Our Case Number: ABP-318758-23

Re: Proposed public realm improvement works known as the "Westgate 2040 Project"
in Drogheda, County Louth

9 February 2024

**RE: Public Realm Regeneration Works in the Westgate Vision Area, Drogheda,
Co. Louth. Ref JA15.318758**

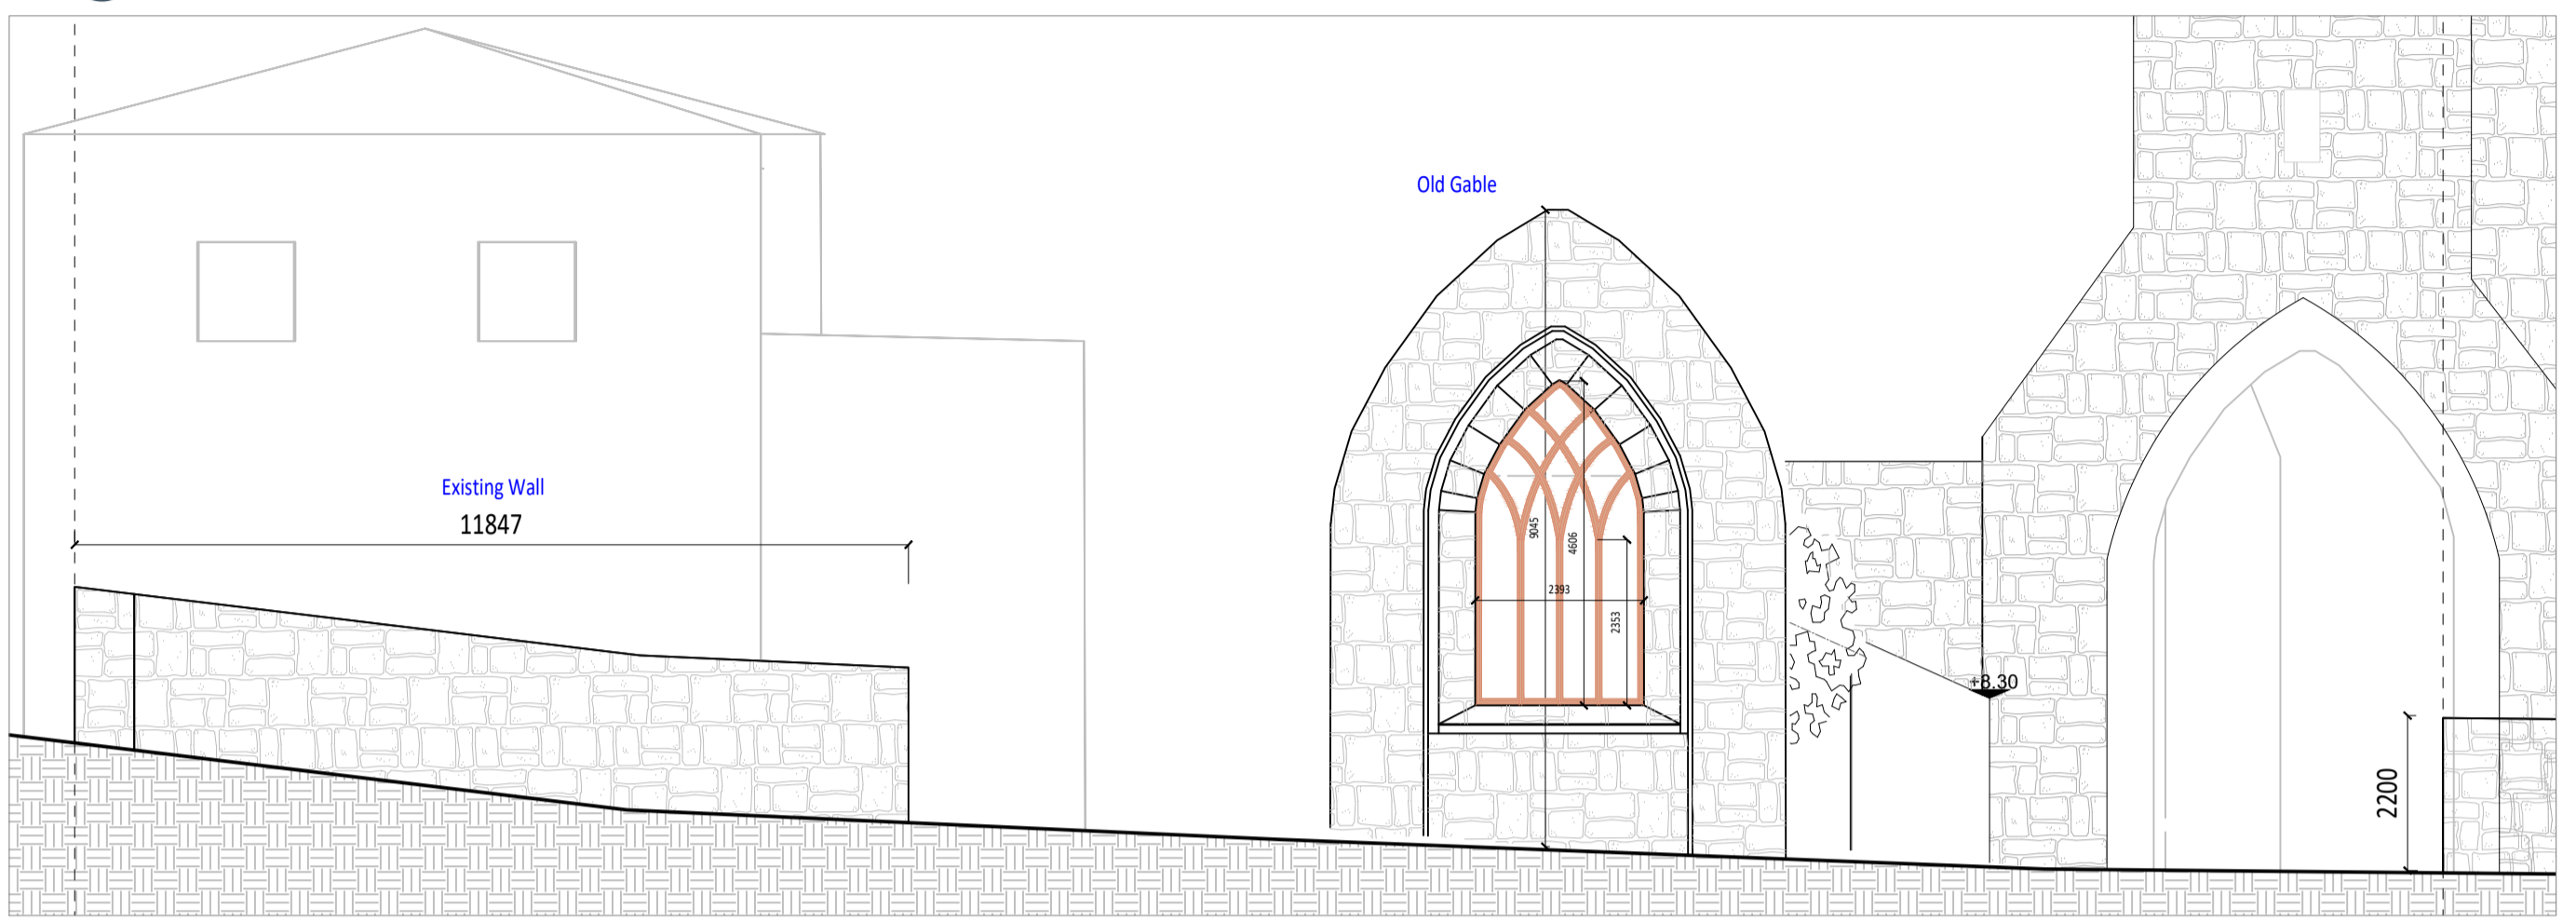
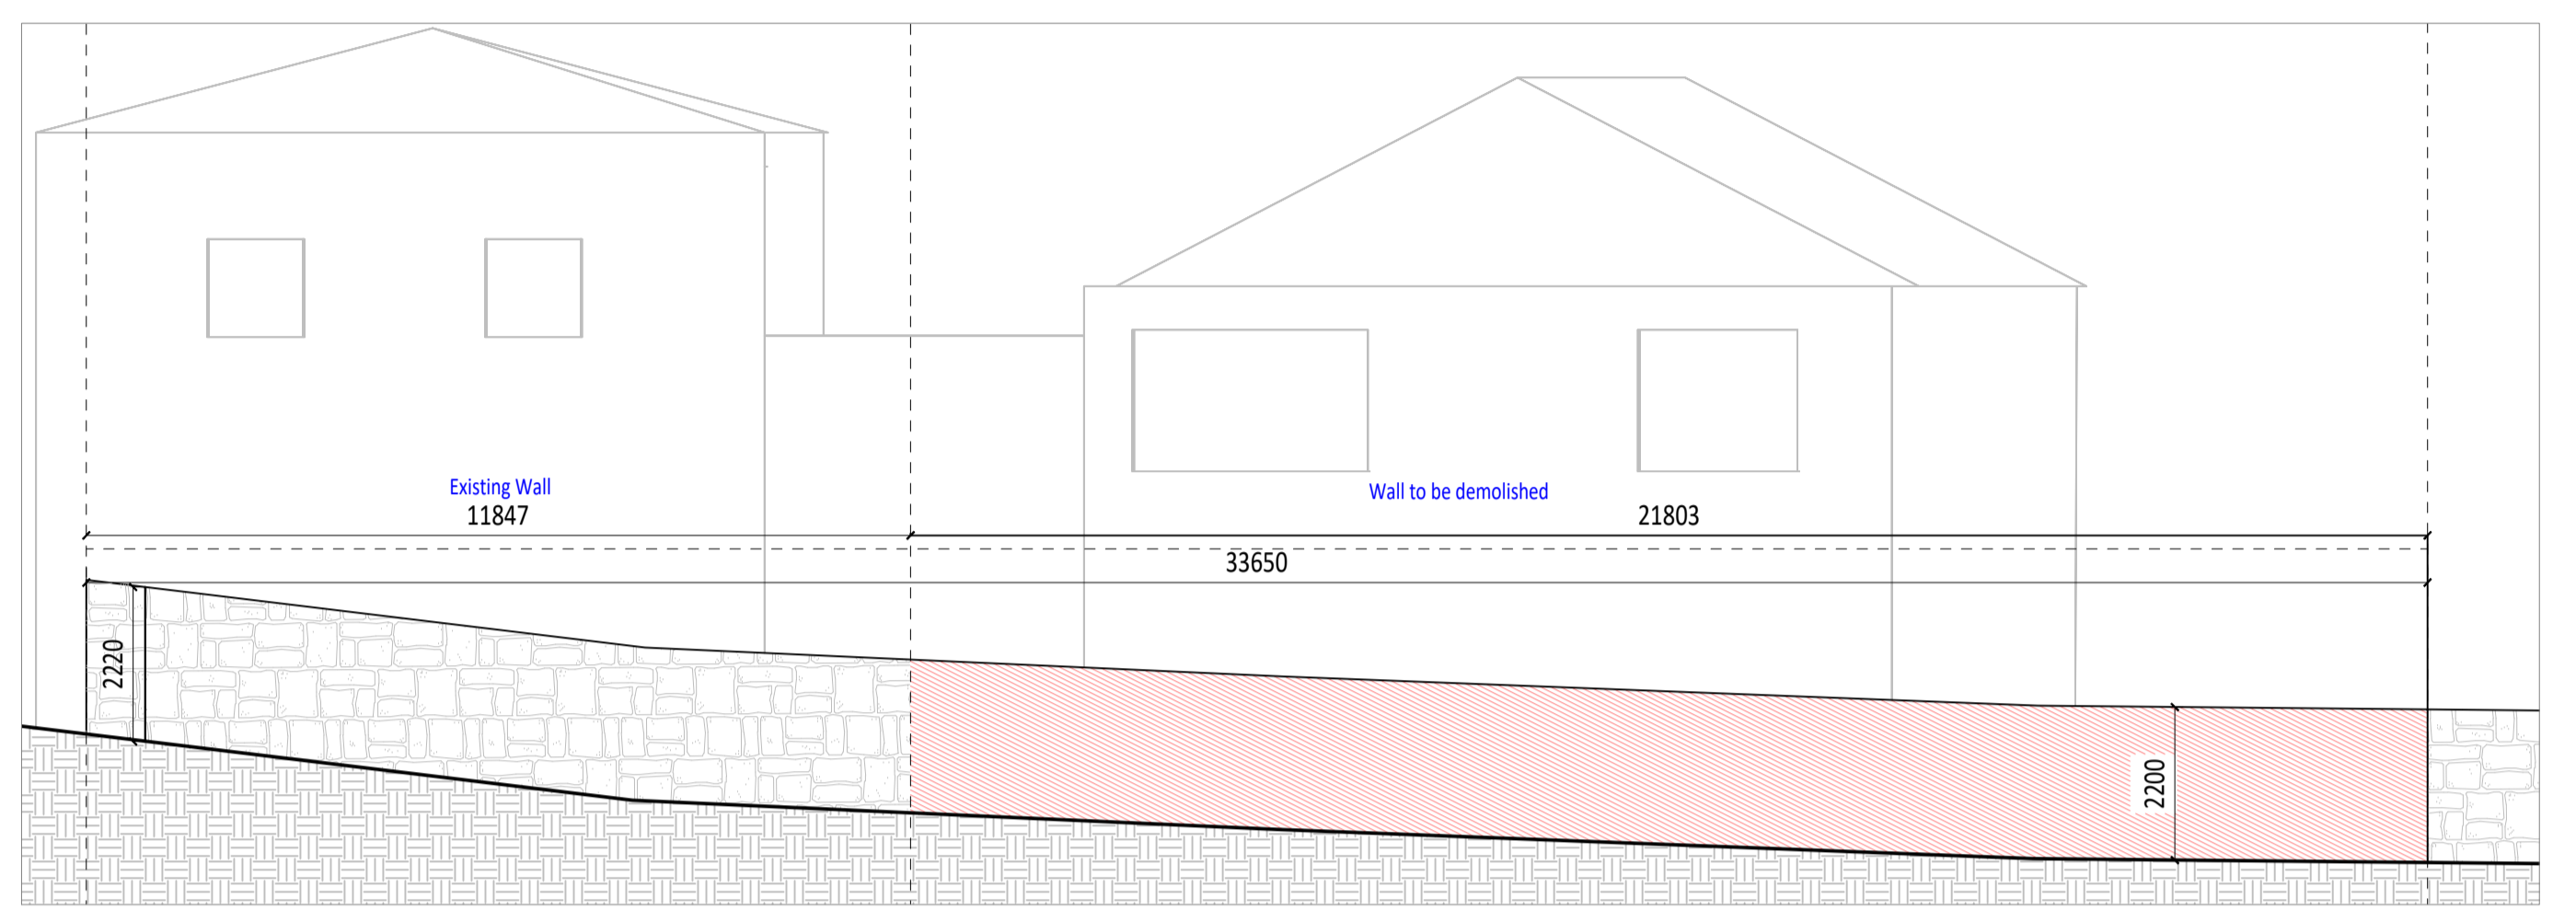
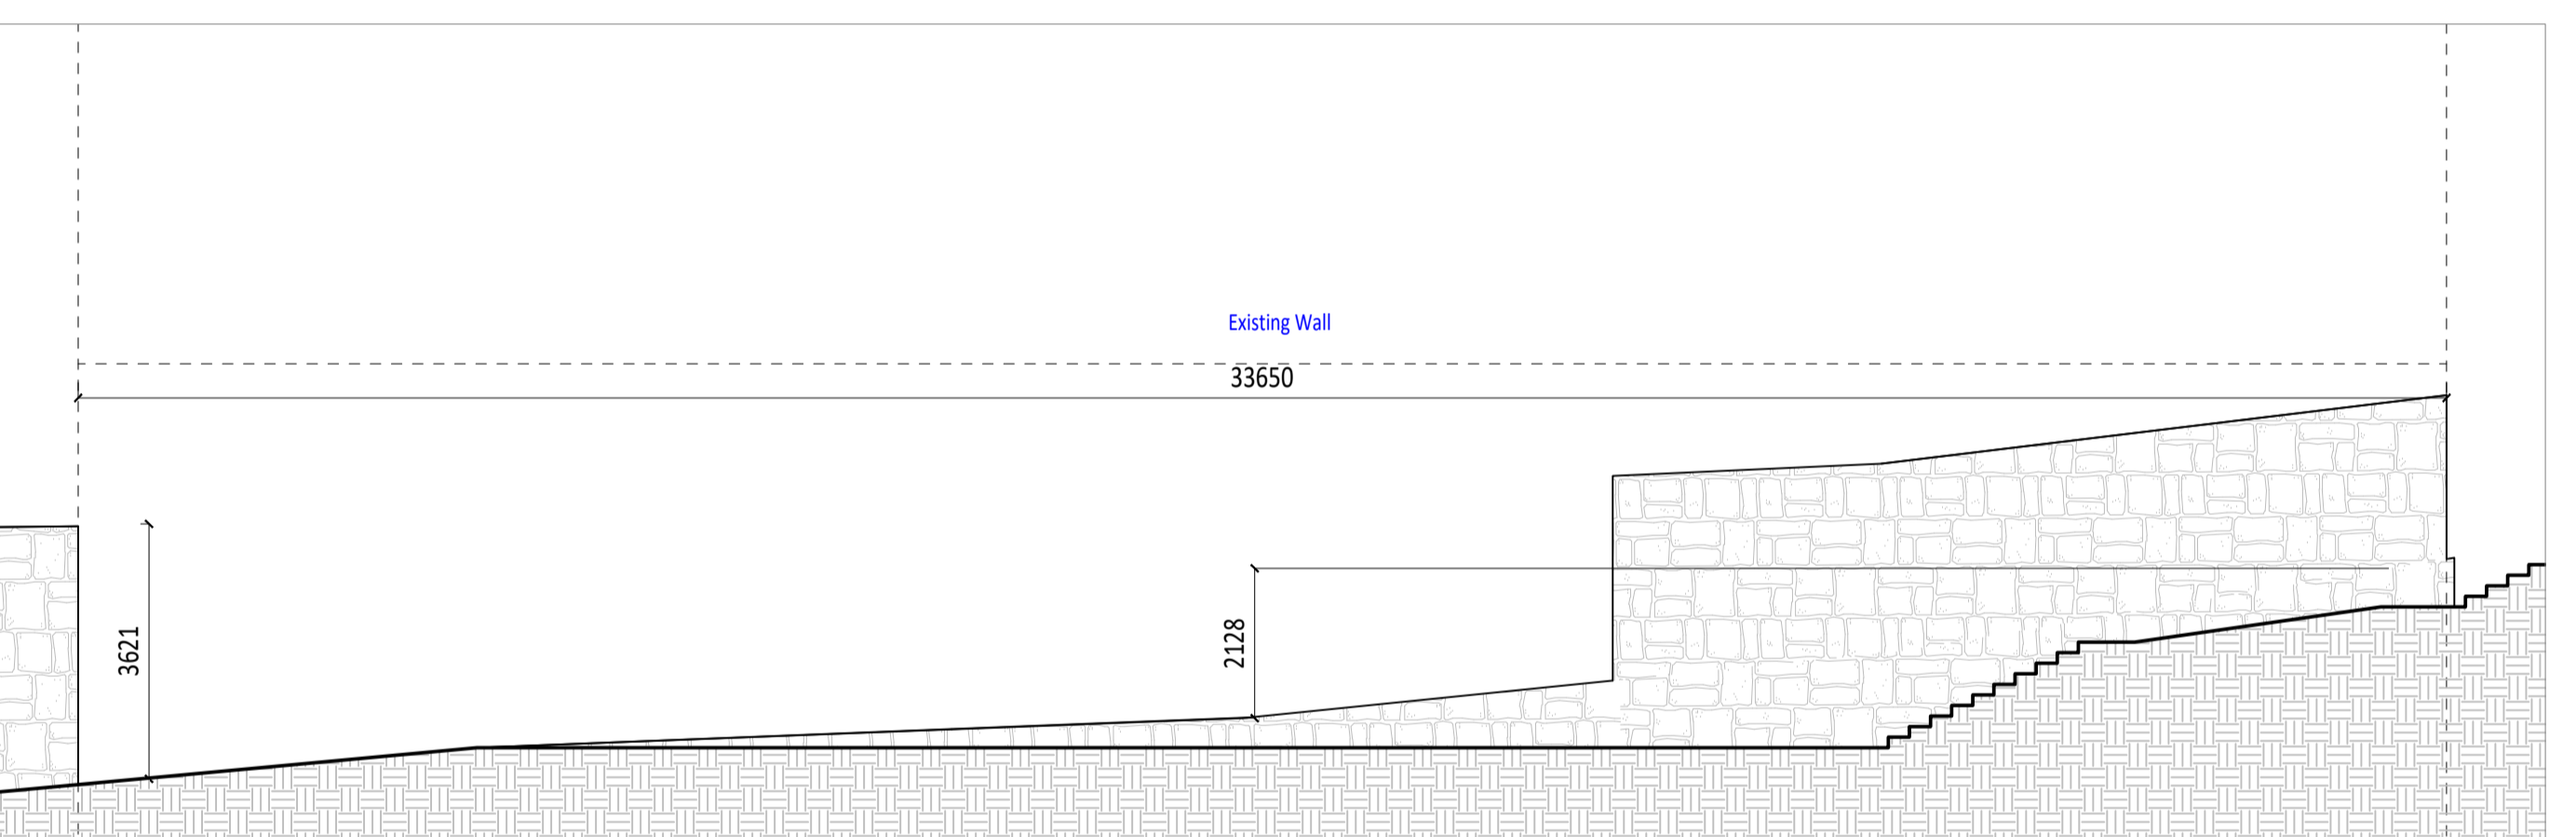
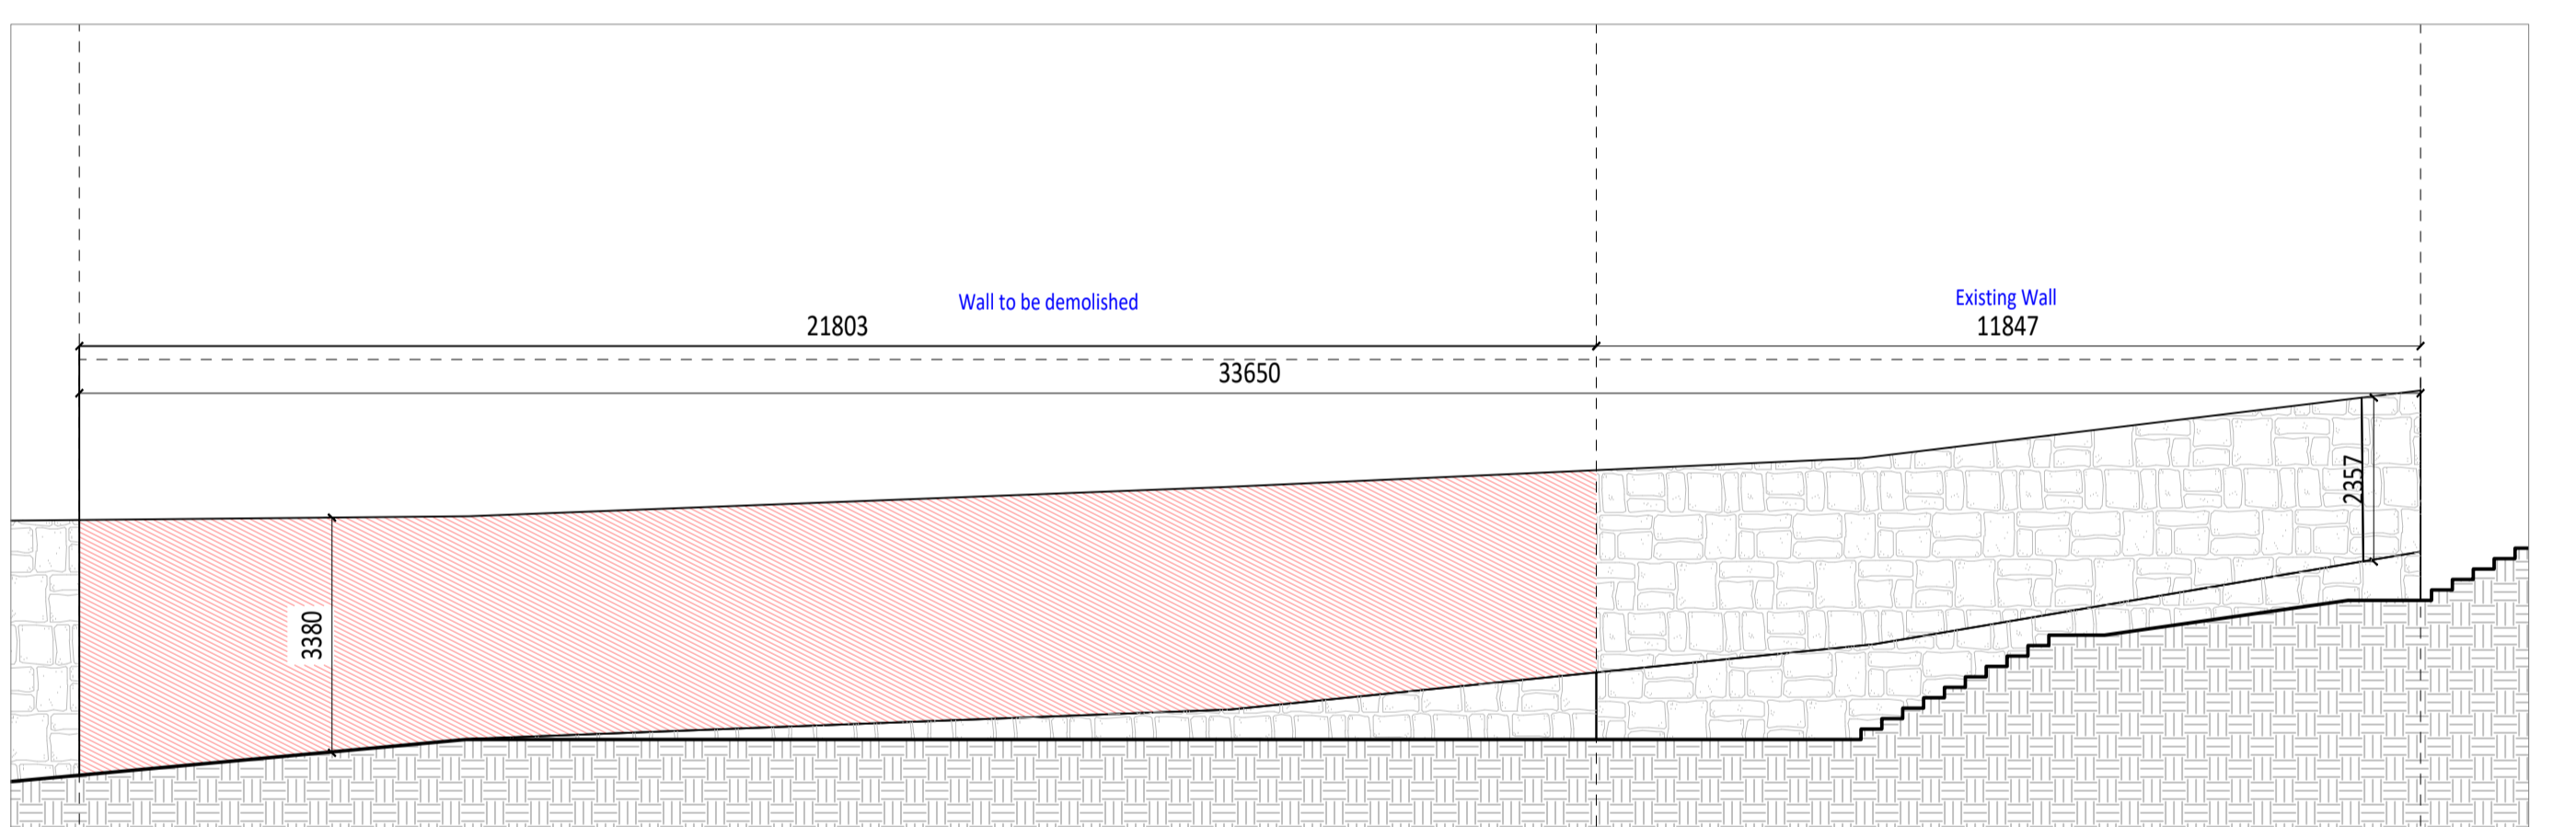
One of the proposals in the development is the 'Demolition of a section of boundary wall located between Old Abbey Lane and Father Connolly Way' (p. 13 in Planning Statement – Description of Development no. 3). I question the need to remove such a long stretch of this stone wall composed of rubble limestone, a feature of Drogheda which is disappearing. The wall would have been the eastern boundary wall of Alderman Barlow's Garden as shown on Ravell's map of 1749. Would a gateway through the wall not be more appropriate than creating a wide-open space? (Note: There is an Ordnance Survey bench mark on one of the stones low down on the east side of this wall).

DRAWING
Detail Drawing 4
Medieval Wall Ground Insert

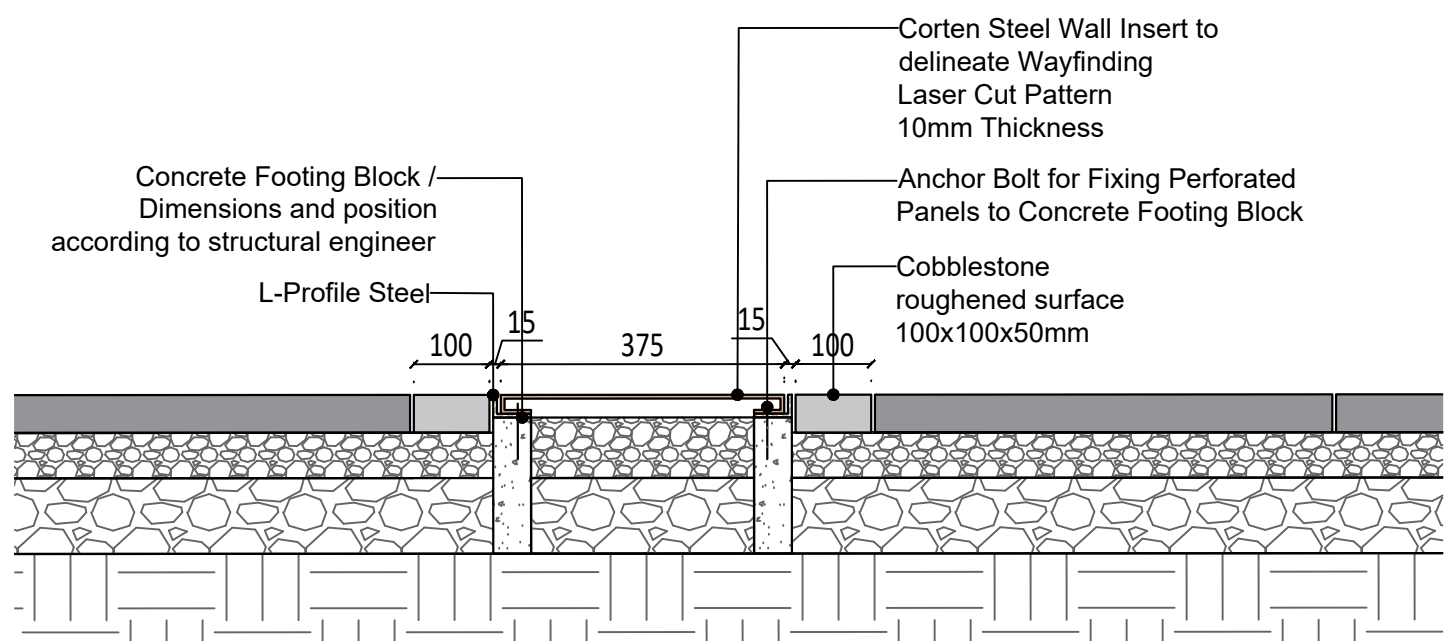
Firstly, I welcome the proposed developments contained in this 'Westgate 2040' application and the aims of the wider plans for the 'Westgate Vision Area' of Drogheda. In particular, the proposed repair and conservation of the neglected stretch of medieval town wall from West Gate to the river is long overdue. Consideration should be given to representing at ground level the circular tower which stood at the turn in the town wall at the riverside. The tower is clearly shown on the 1698 *View of Drogheda from St John's Hill* by Francis Place (Fig. 1 below). Excavation would be required to determine the exact location if this is not already known.
